Address: Freckleton B Bristfield Road Dewsbury Wf12 0NX

Application number: 2022/93579	
What is the application for?:	Erection of two storey and single storey extensions and external alterations
Address of the site or building:	Freckleton A, Bristfield Road, Bristfield, Dewsbury, WF12 0NX
Postcode:	WF12 0NX

BASEMENT
 as proposed
 Scale 1:50 @ A1
 Demolition
 New walls
 New structure to be designed by Structural Engineer

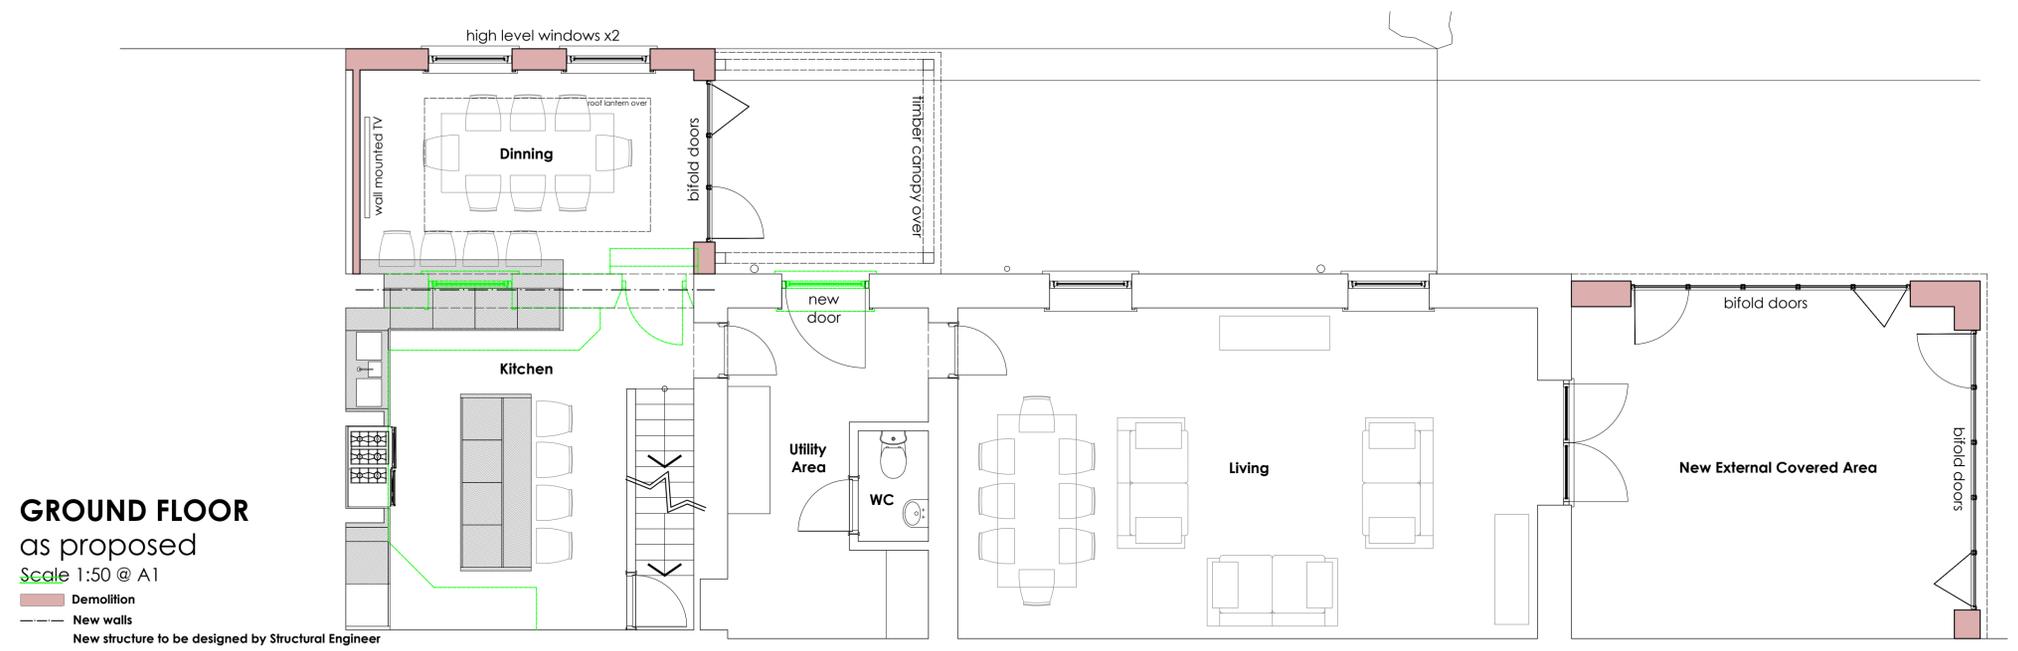
Type of comment: An objection	
Do you wish your comments to be published on the website anonymously?	No
<p>After seeing the plans amended again, I object to the basement frosted window 'for fire escape use only' as this is facing into neighbours property at ground level which will cause an invasion of privacy. There are no reasons why the owner could not put a window on other walls of the property which would on-look their own land. Whether this window is frosted or not it does not want to be on looking into neighbours garden, the neighbours garden is not for their fire escape use and is private property, the owner needs to use other external walls for this window that does not intrude with neighbours land or garden.</p> <p>The permission for the basement bedroom has not been approved but the work has already been completed.</p>
